Application Reference: P/107/25/DOC Site Name: Land West of Hook Lane Pagham PO21 3PB	Initial Issue Date: 12/12/2025 Issue Date: 12/12/2025 Reviewer Reference: ADC/EXT4
--	--

Summary and Recommendation:

Condition 9: **Further information required**

C002

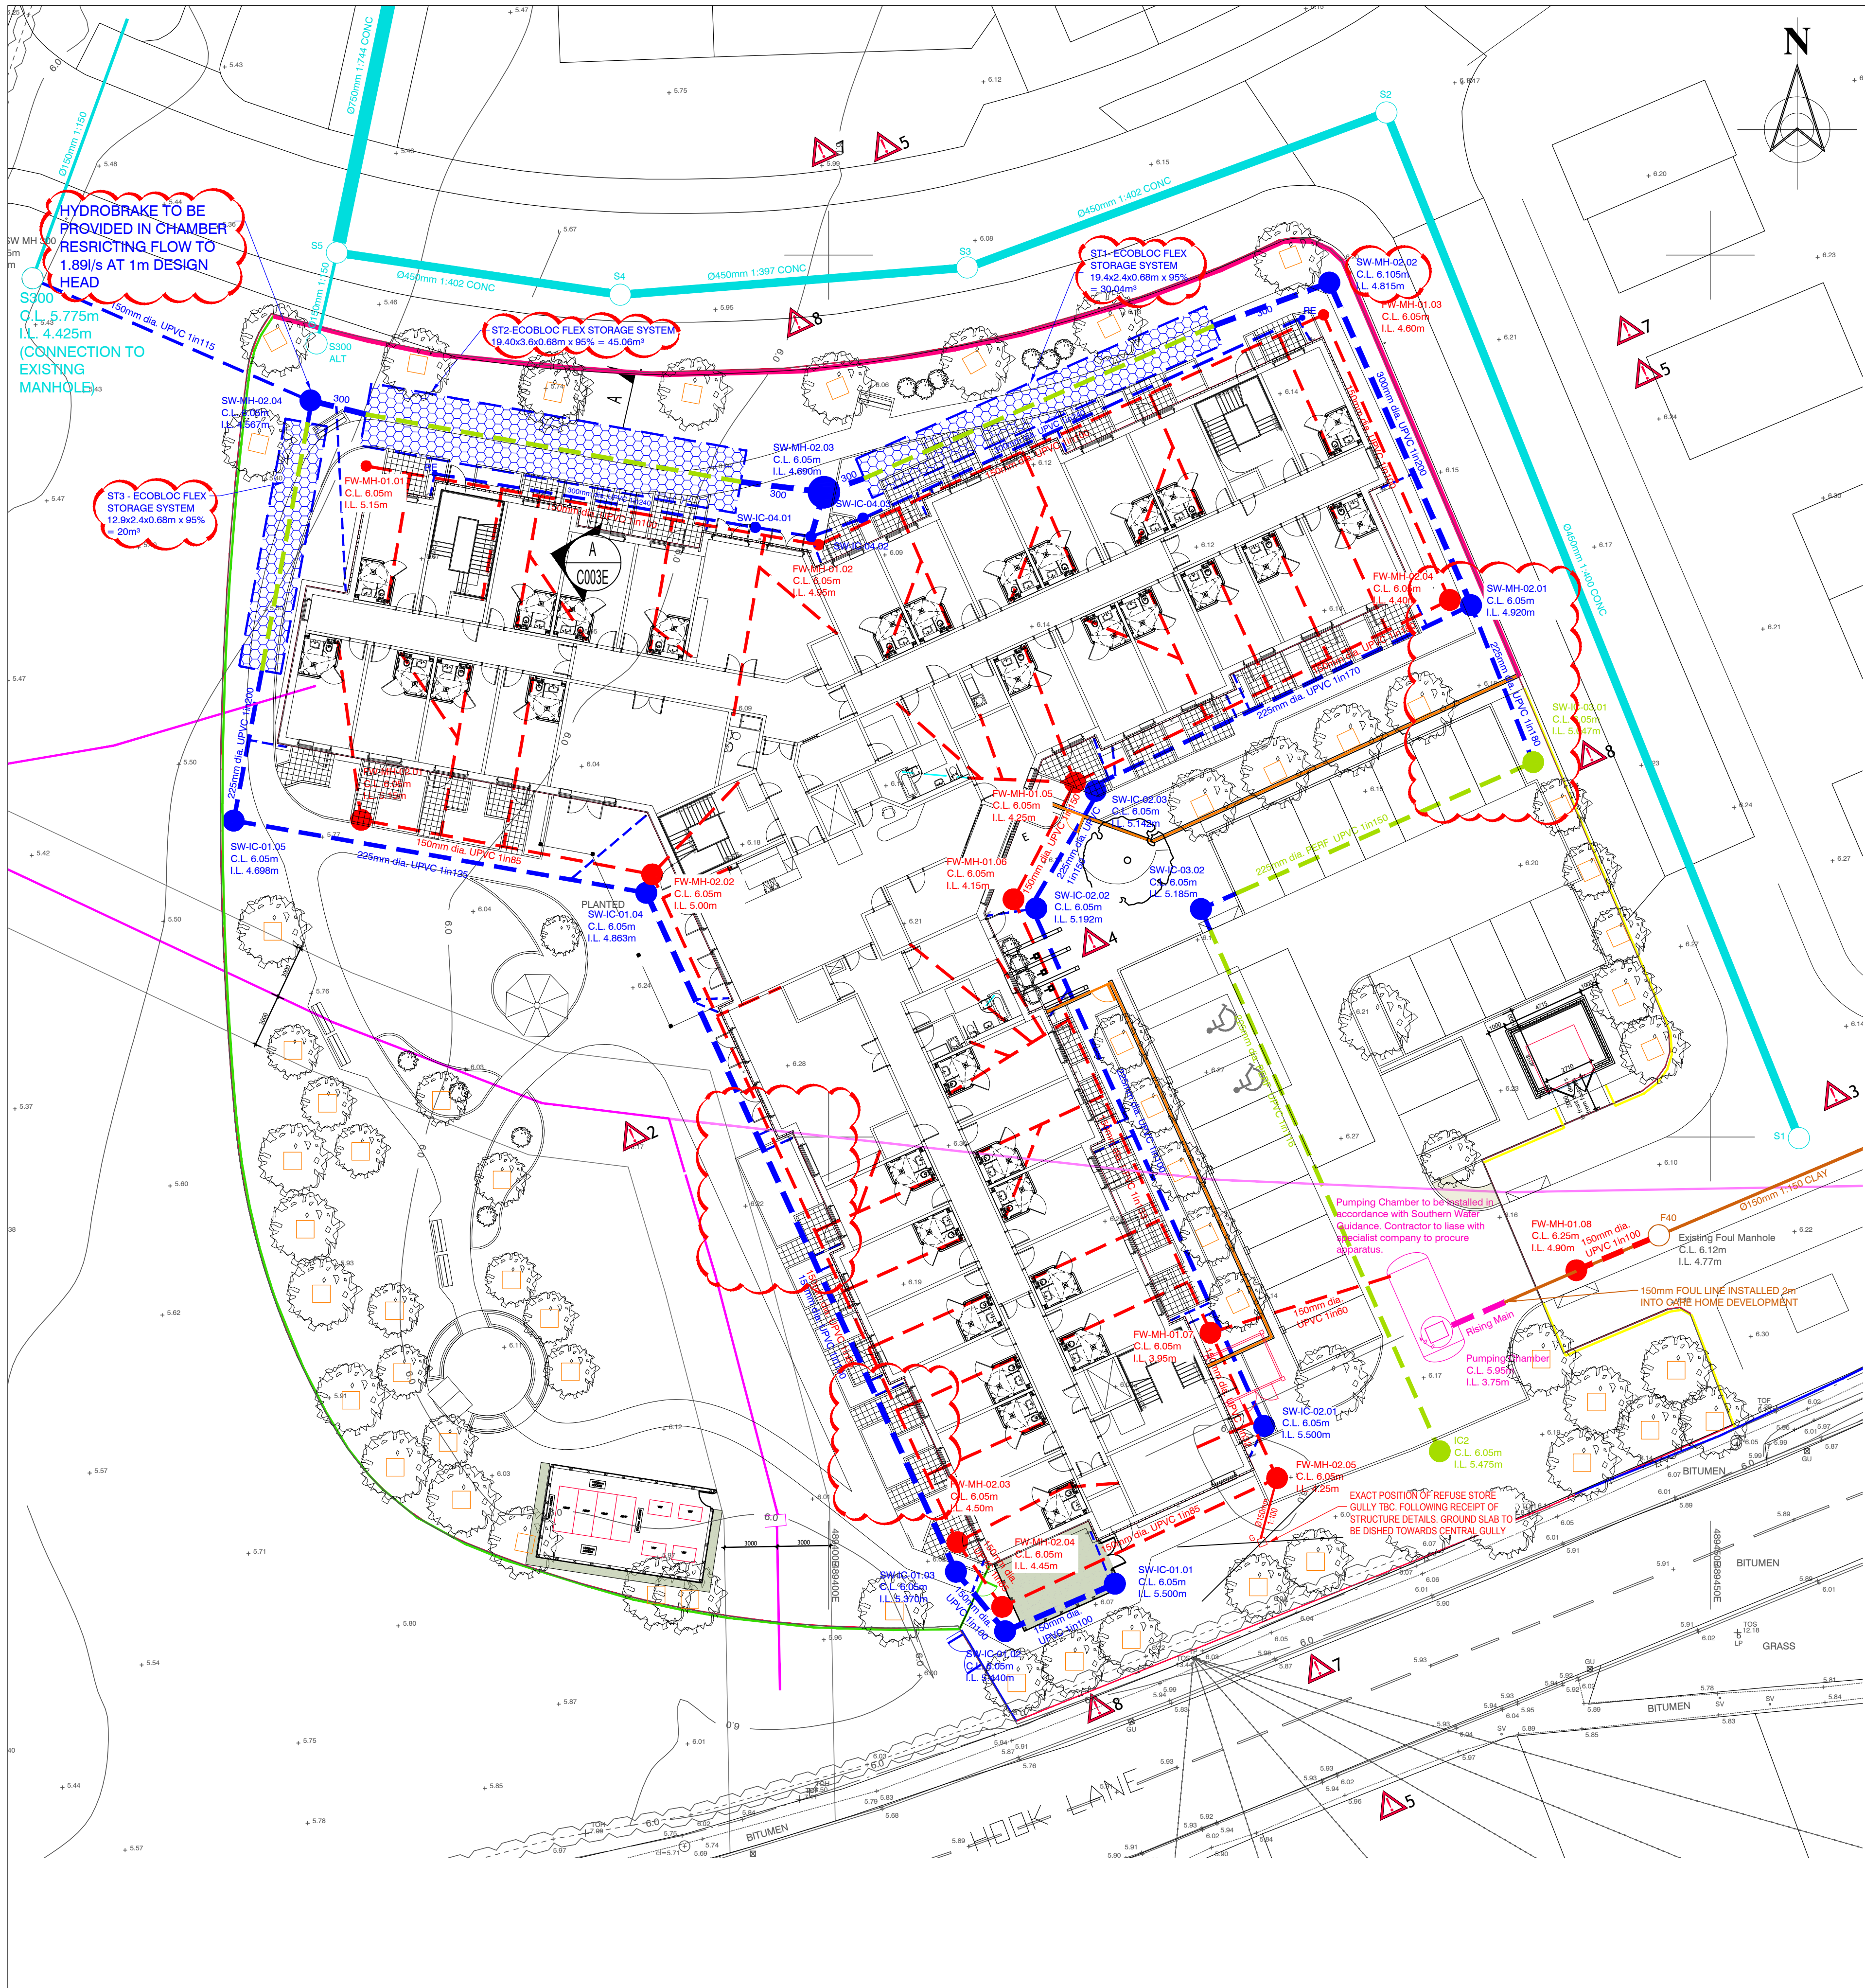
d) The long sections do not include levels for the drainage components e) See comment 6 Provide accurate and coordinated drawings	D. Updated Drawings & Calculations. E. Point 6 has various responses that have been answered.			
10	The current level of detail provided on the Drainage layout drawing 9418-C002 is insufficient. a) There is no north point or key b) There is potential for surface water to enter the foul pumping station via the turret/cover, where it passes through the permeable paving. Provide a detail showing how this will be prevented c) There is potential for surface water to enter the foul water system via FW MH-02.05, as it is located within the permeable paving. Provide a detail showing how this will be prevented. d) There are some large areas of paving around the	A. Updated Drawings & Calculations. B. See Appendix I. C. See Appendix F. D. Rev. C calculations. See levels and Drainage	a. item now closed b item now closed c. item now closed d. item now closed e. item now closed f. item now closed g. item now closed h. item now closed

building which do not appear to be drained e) The drawing of manholes/ inspection chambers is inconsistent with the schedule size f) The invert levels are not consistent with the manhole schedules, long sections or calculations g) Make it clear on the plan where the flow control chamber is h) The point of connection to the existing manhole is not clear and the existing manhole data is missing Provide accurate and coordinated drawings	drawings provided. Updated Drawings & Calculations. F. See Rev. C calculations updated previously. Updated Drawings & Calculations. G. Responded in Rev. C Calcs. Flow control is clearly marked on Drainage plan and Construction details. H. See Rev. A calculation provided previously. Updated Drawing.			
11	Provide a detailed level design to clearly demonstrate that surface water run off will discharge to the proposed gullies/permeable paving etc. and not cause a risk of flooding to the building or off site. A) There are some large		A Item now closed B item is still outstanding please provide formation levels on plan for the permeable paving	See Appendix K for proposed formation levels.	Item now closed

Client	Simply UK	 CHARLES SCOTT & PARTNERS CONSULTING ENGINEERS
Location	HOOK LANE, PAGHAM, PO21 3PB	
Drawing Title	ST1-ST3 GRAF ECOBLOC DETAILS

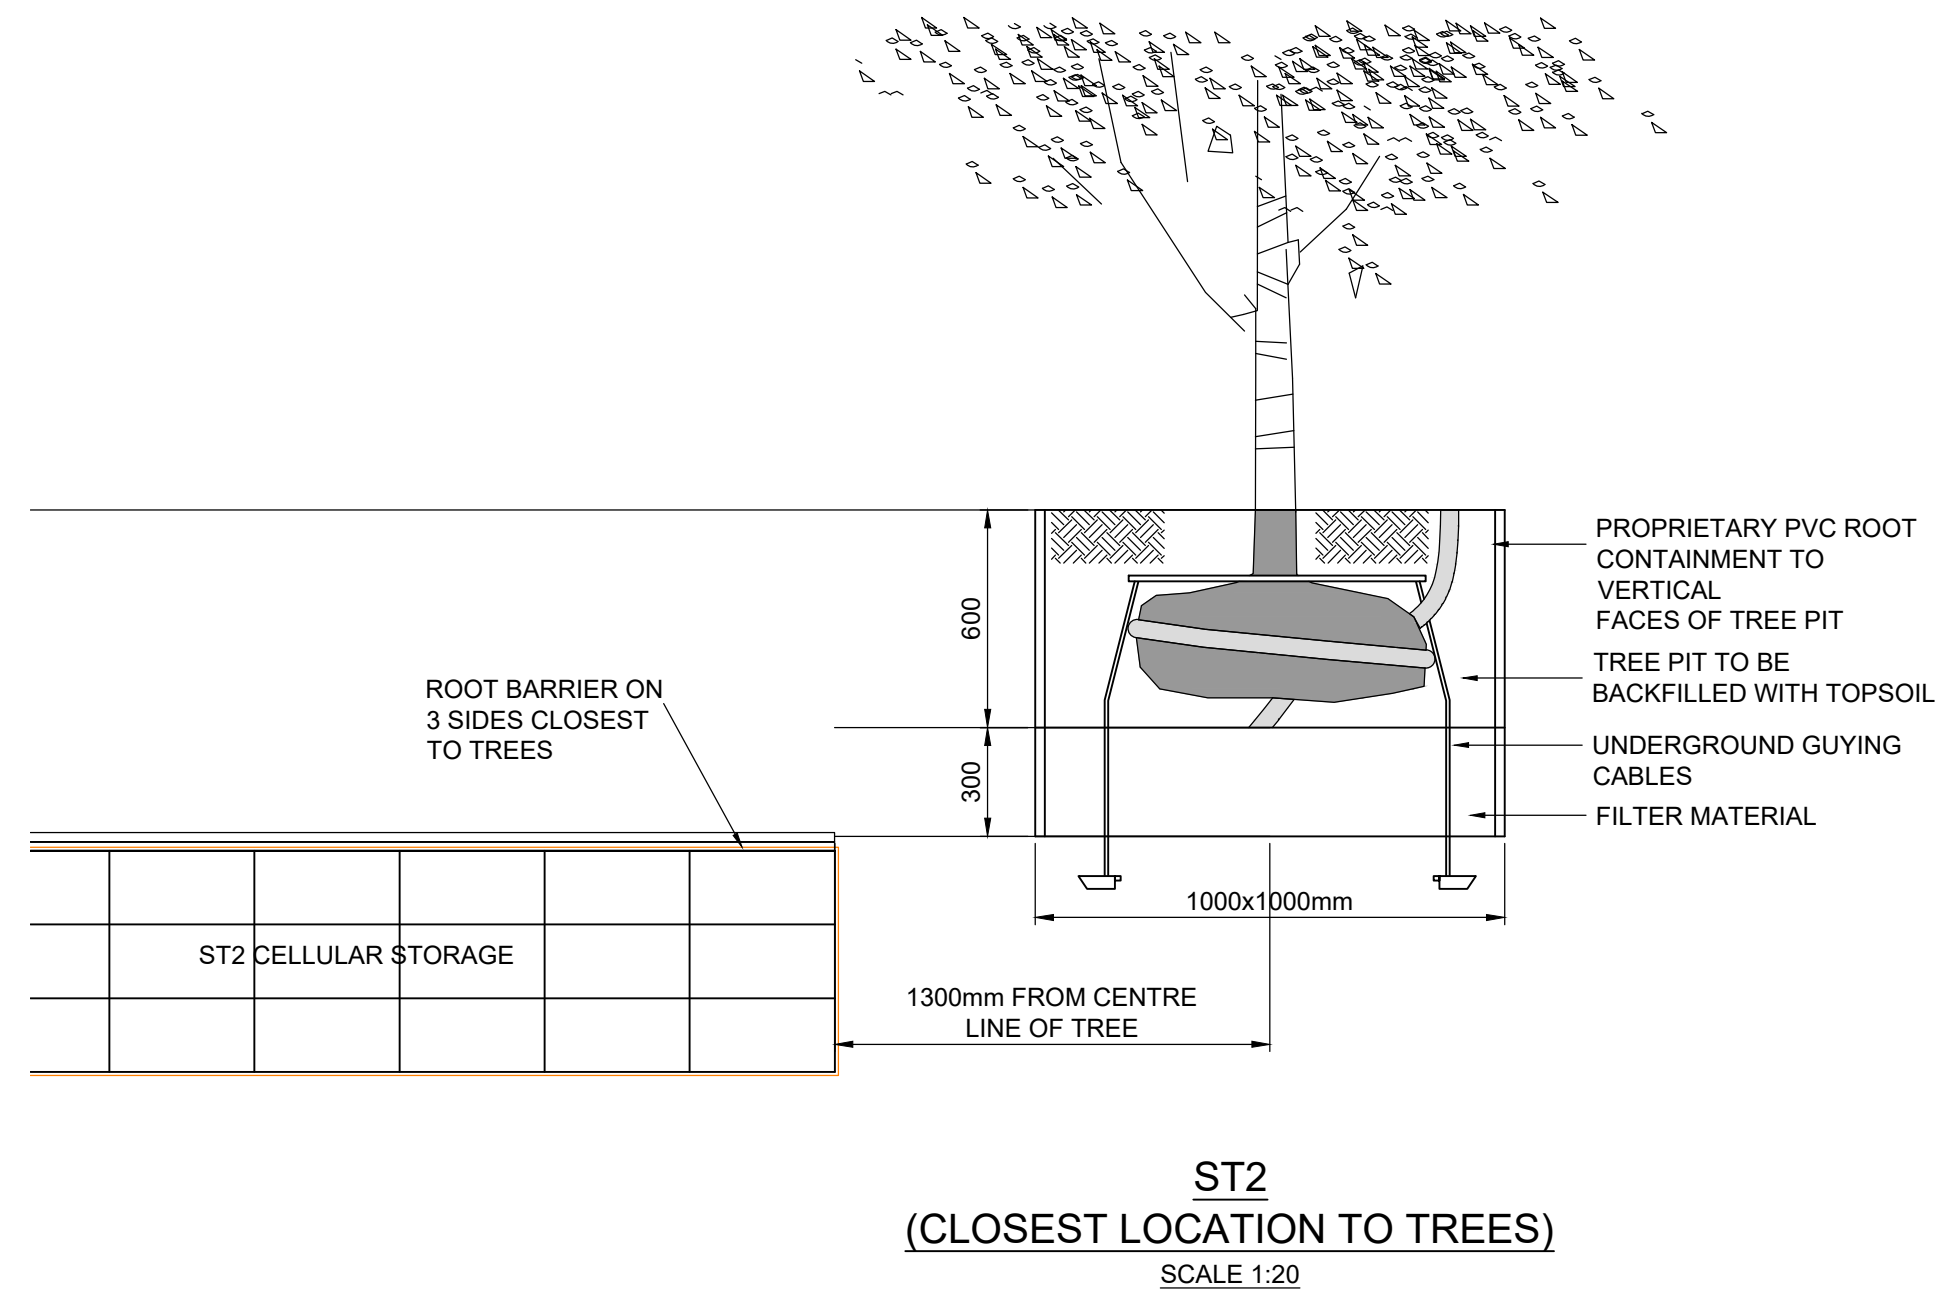
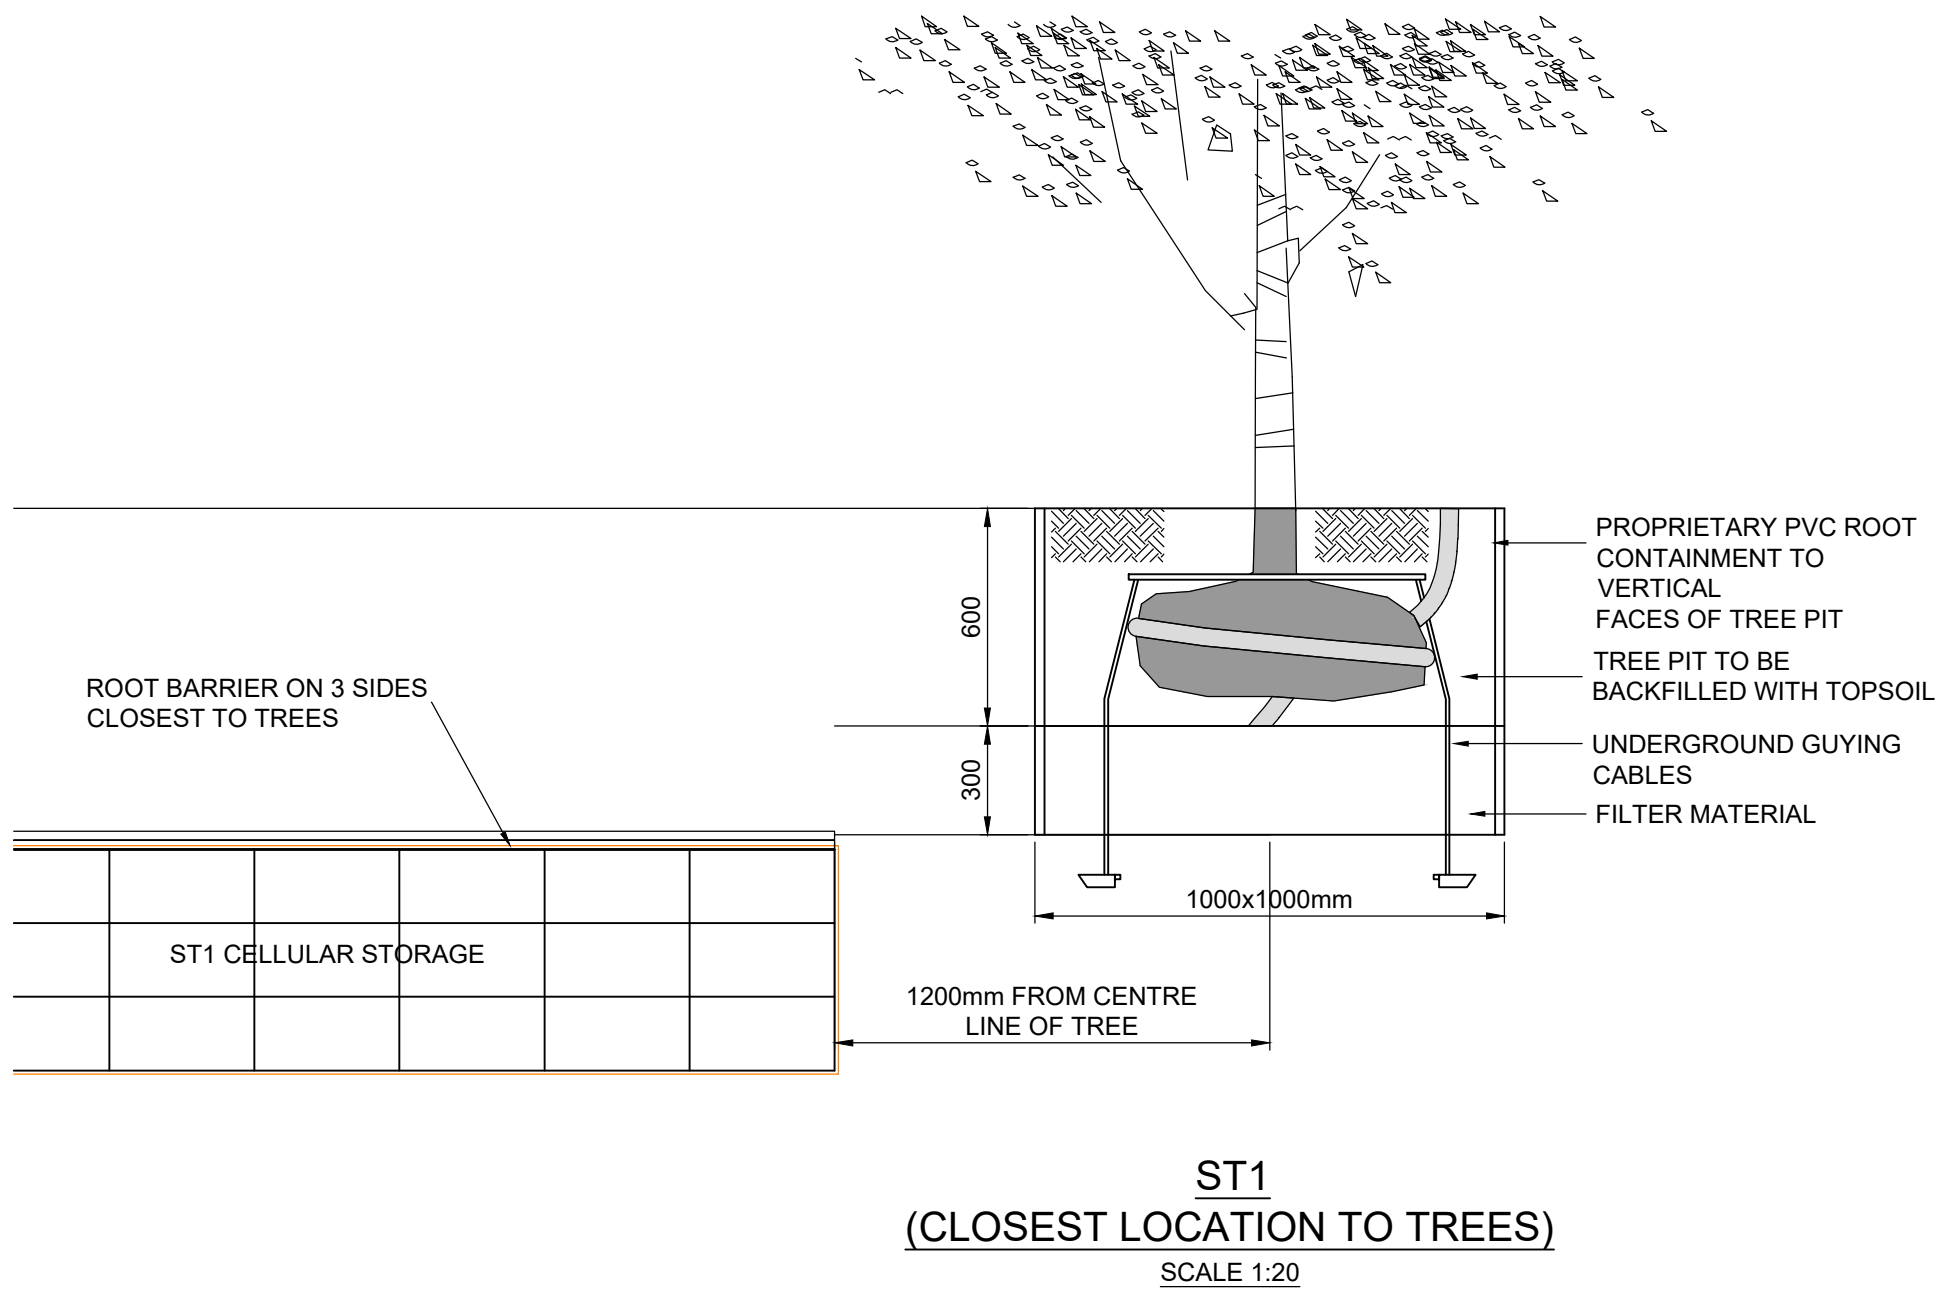
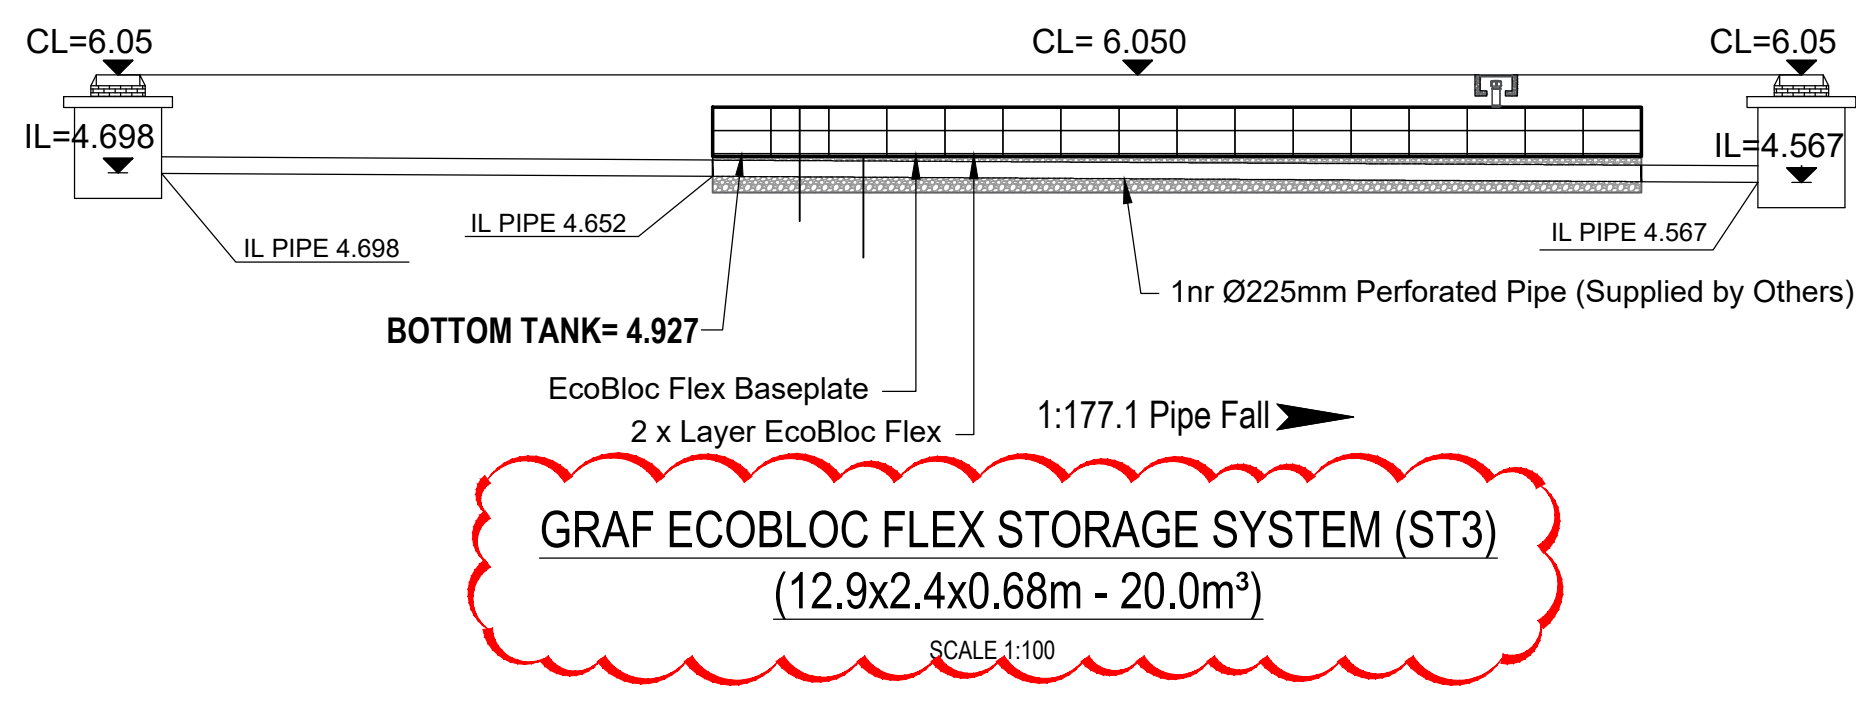
to the upstream and downstream chambers, no details are provided showing how these chambers are vented e) The tank detail suggest that pipes run through it at base level, this is not shown on the plan f) The tank detail refers to Ecobloc and Stormcell, the plan refers to Aco Stormbrix. g) The tank detail does not state which specific product in the range it to be used. eg. There are 3 types of Stormbrixx h) The tank detail specifies a plan size that is not consistent with the drainage plan i) The tank detail makes reference to “final detailed design by Ecobloc. Provide the final design j) The permeable paving detail shows a 150mm perforated pipe, the	F. Rev. C calculations. GRAF ECO block MAXX clearly shown. Updated Drawings & Calculations. G. Updated Drawings & Calculations. H. Rev. C Calculations. Updated Drawings & Calculations. I. We have removed this note. This should be forwarded later after PLANNING. J. No impact. Updated Drawings & Calculations. K. Rev. C Calculations - Updated Drawings & Calculations. L. As shown on details – steel cable connected to pivoting bypass door for blockages as shown on C003 drawing.	comment to A F. Item now closed G. Item now closed H. Item now closed I. The detailed design of these tanks are required to support this condition J. Item now closed K. Item now closed L. Item now closed M. item now closed N. Item now closed O. Item now closed P. P. Item now closed	See Appendix H for detailed Graf Drawings.	I. Item now closed
